Please ask for: Nicola Moore
Email: nicola.moore@arun.gov.uk
Telephone: Ext 37944
Our Ref: AW/109/20/HH
Your Ref:
Date: 4th May 2020

Application for Planning Permission for Works or Extension to a Dwelling

Development: 1st floor rear extension, removal of existing conservatory and erection of single storey rear extension and detached car barn
Location: 16 Barrack Lane Aldwick PO21 4BZ

sheet 1 of 5

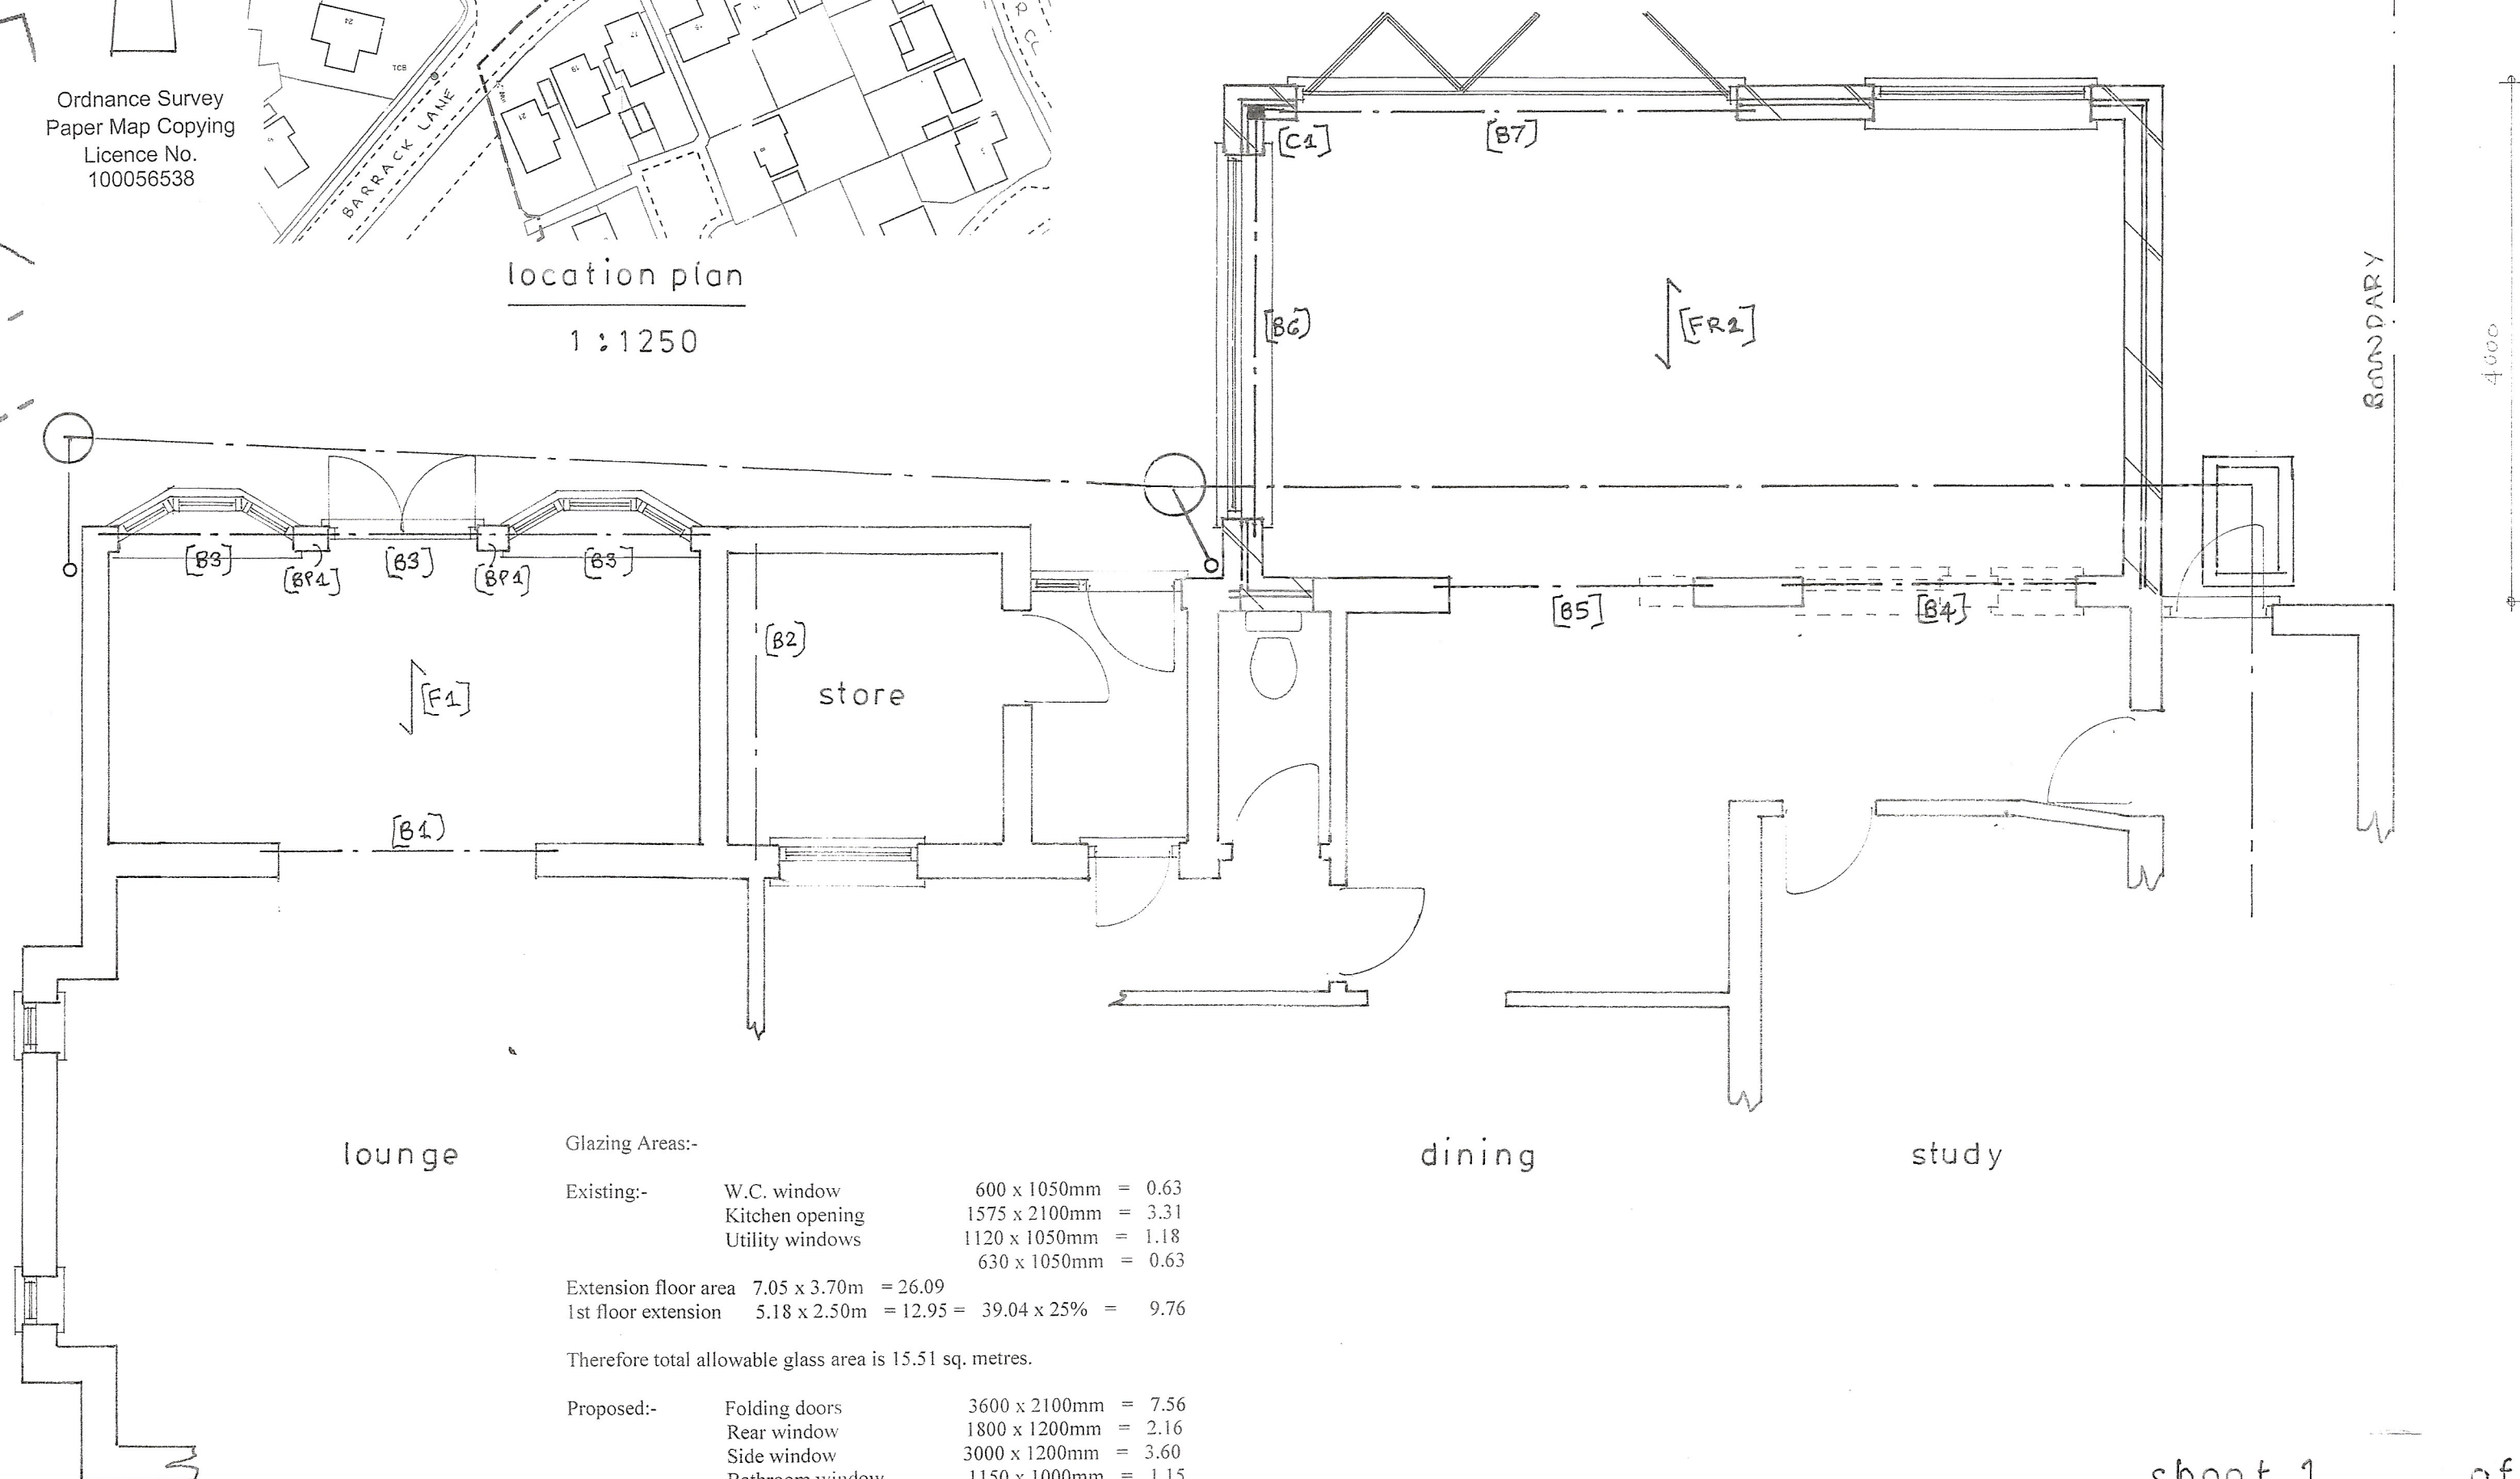
The single storey ground floor extension floor plans and elevations do not scale correctly. Please check the scale and measurements, amend accordingly and re submit.
